WATERLOO METRO QUARTER OVER STATION DEVELOPMENT

Environmental Impact Statement
Appendix H – BCA and DDA Assessment Report

BCA & DDA Assessment Report

Waterloo Metro Quarter Development
Building 2

OVERALL ARRANGEMENT - GROUND FLOOR

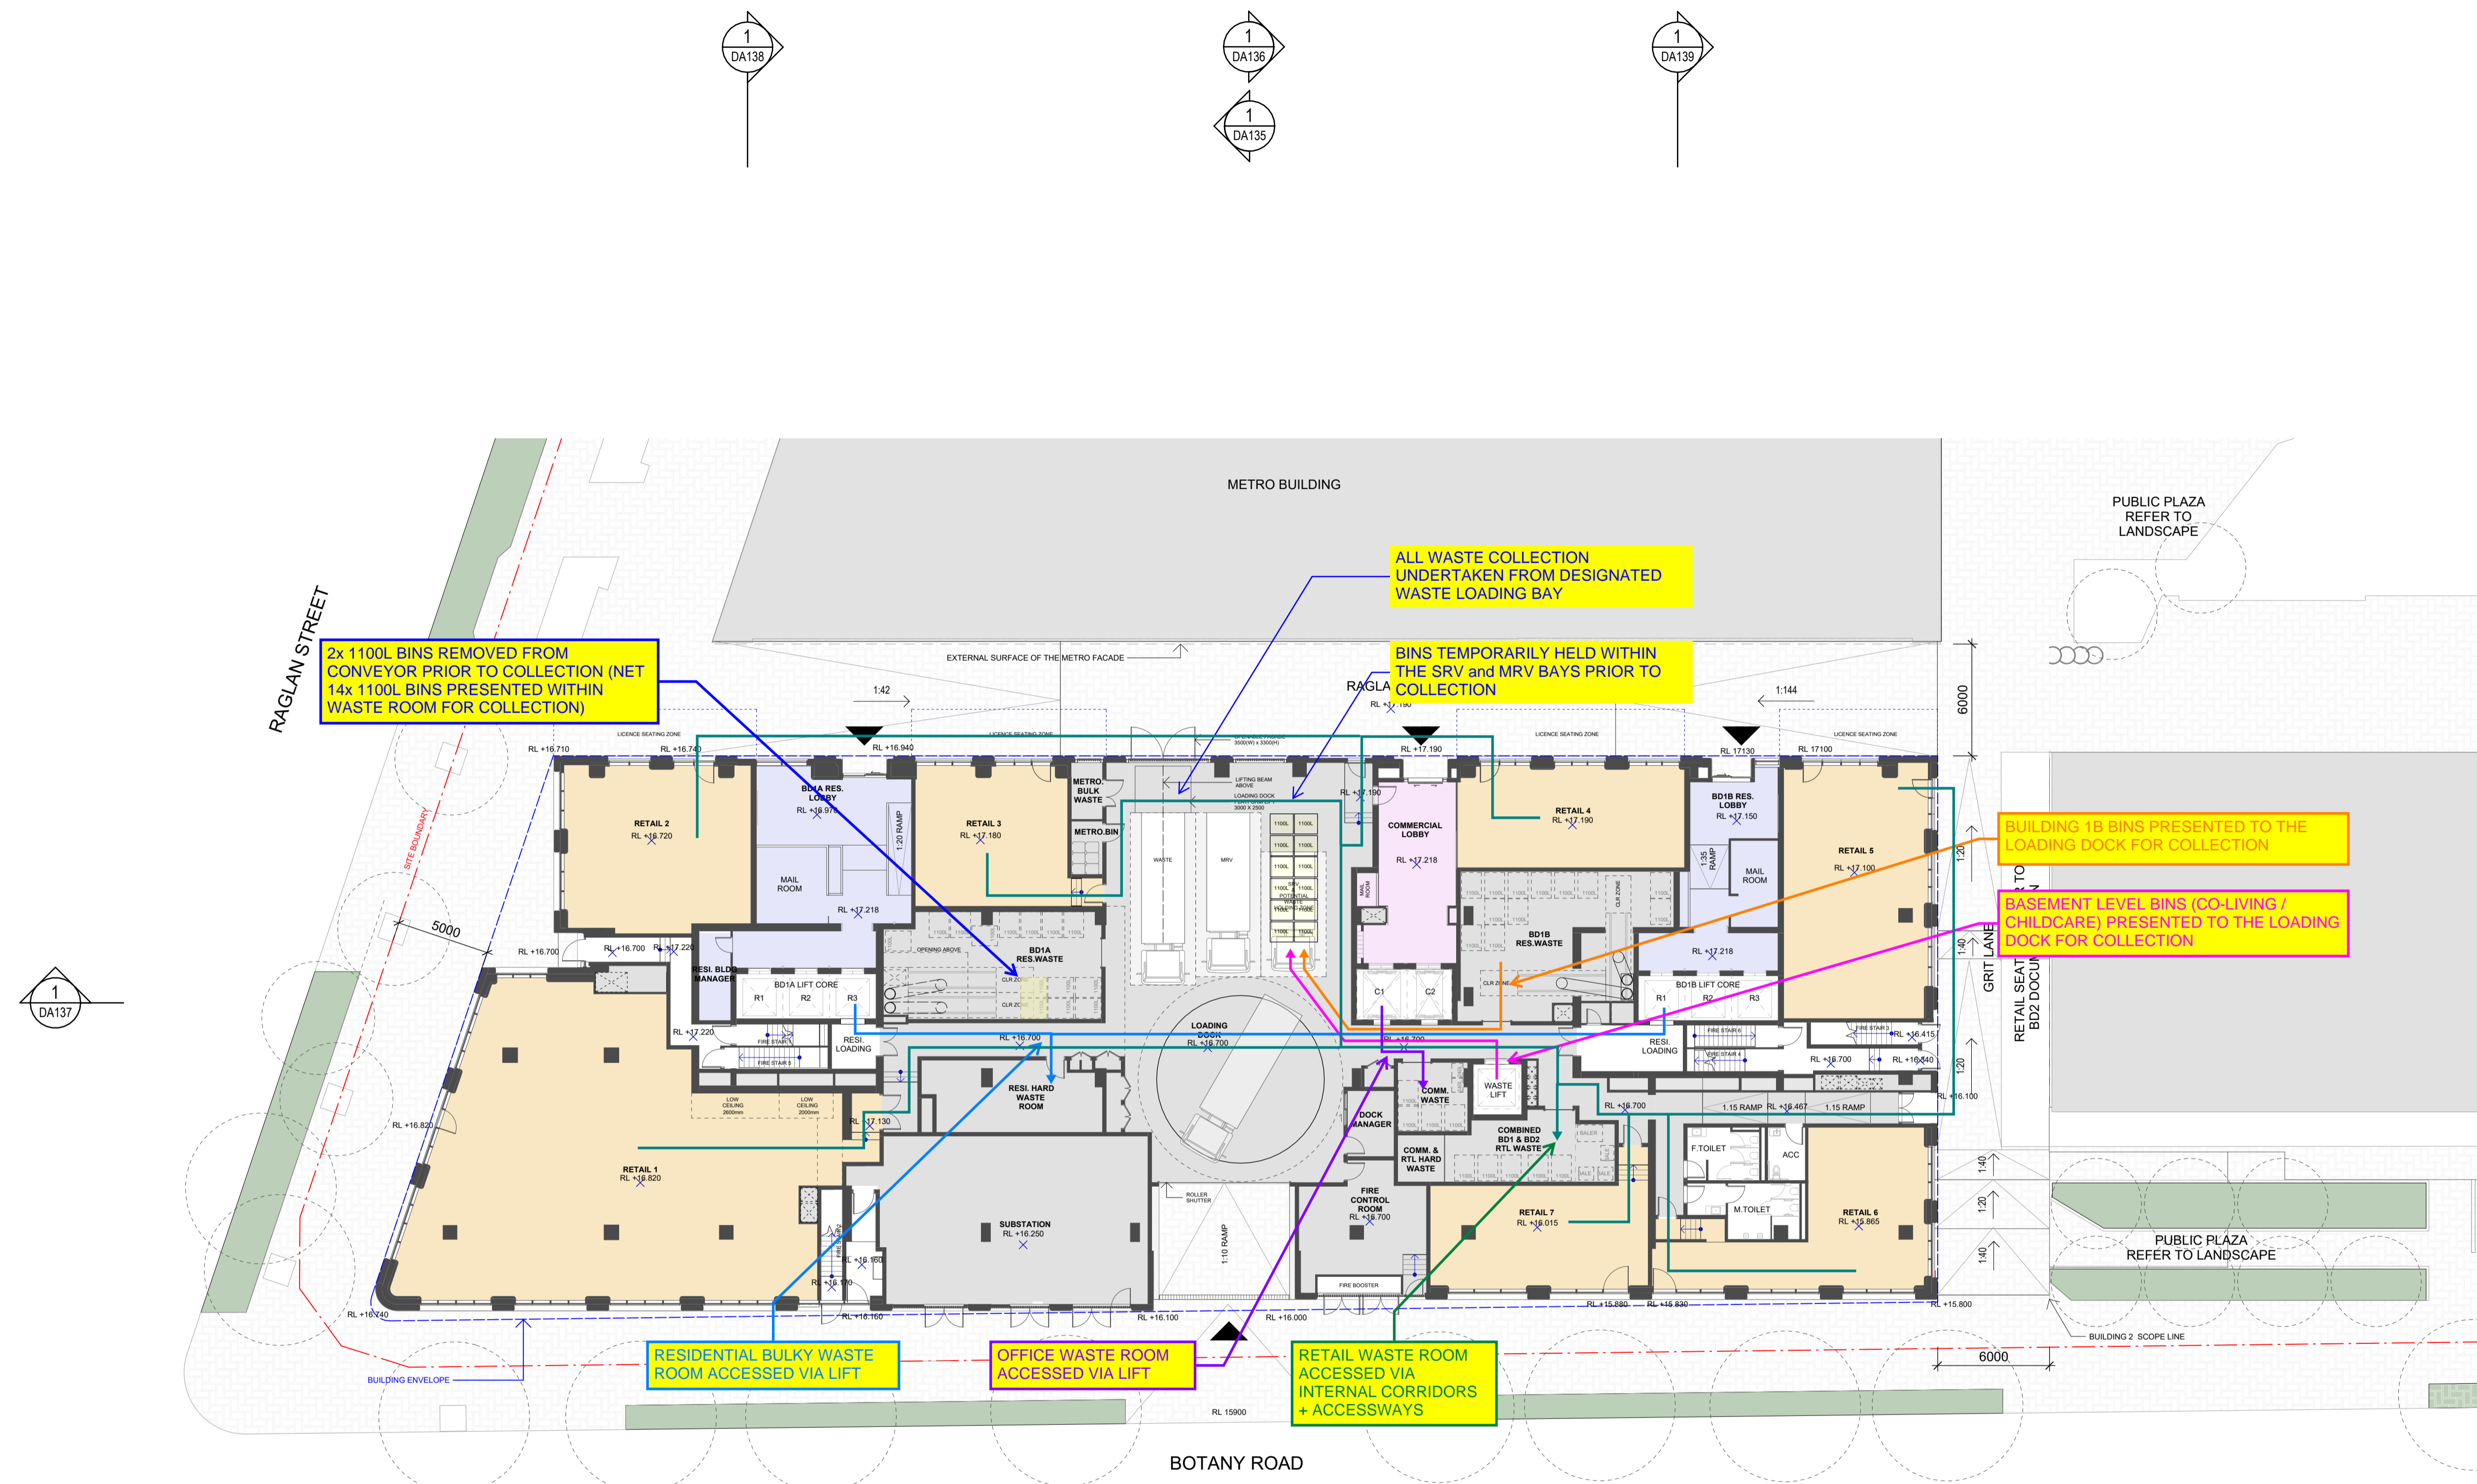
13.	D3D27	Confirm method of re-entry for fire-isolated stairs. Typically dealt with as a performance solution to rationalise extent of intercoms.
14.	E1D2	+ The hydrant booster is not within sight of the main entry. + Fire services designer to verify any fire hydrant non-compliances, such as booster location and hydrant locations

15.	E1D3	Fire services designer to verify any fire hose reel non-compliances.
16.	E1D4	Fire services designer to verify any sprinkler non-compliances.
17.	E1D15	The fire control room does have direct access to the entrance of the building. The front entrance of the building is considered to be the residential and commercial lobbies.

OVERALL ARRANGEMENT - LEVEL 1

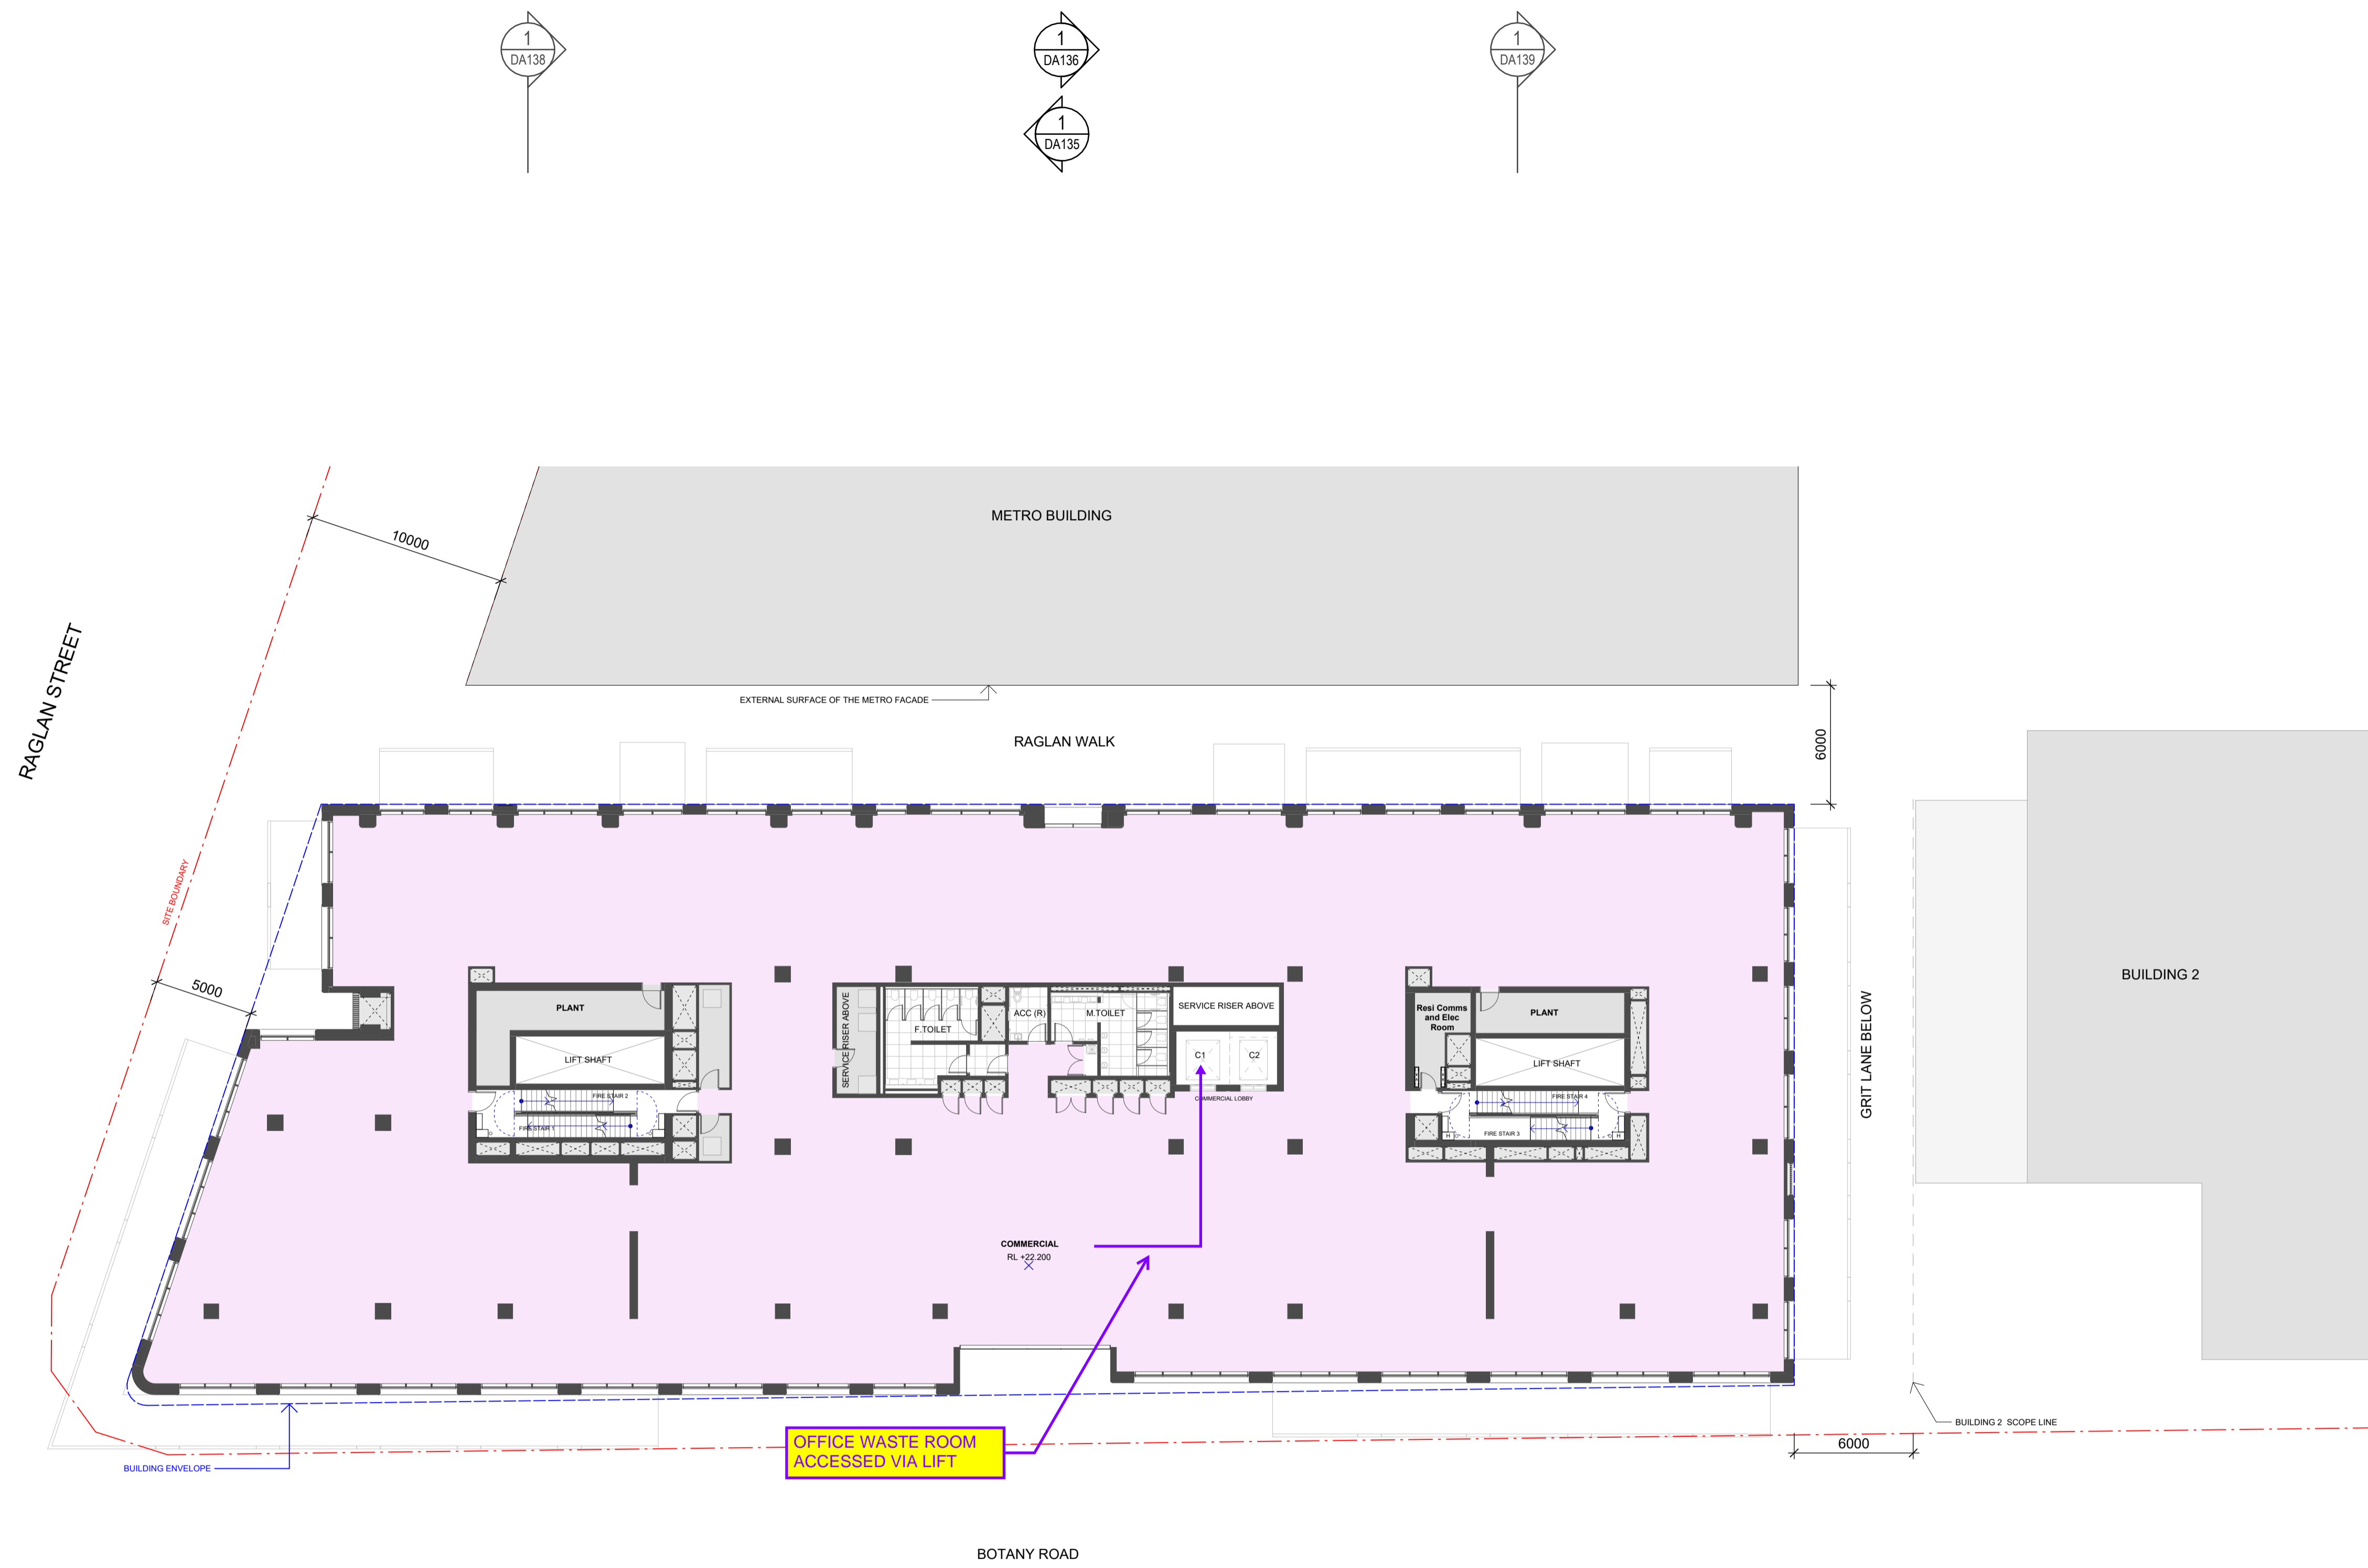
2.	D4D4 – doorway circulation	The cot room in playroom 4 of the childcare centre does not achieve doorway circulation. Either provide or we can support as a performance solution.

3.	F4D4 – unisex facilities	To allow the childcare staff sanitary facilities to be unisex.
4.	F4D4 – childcare kitchen	The childcare kitchen area is not capable of facilitating supervision of children younger than 2 years hold.
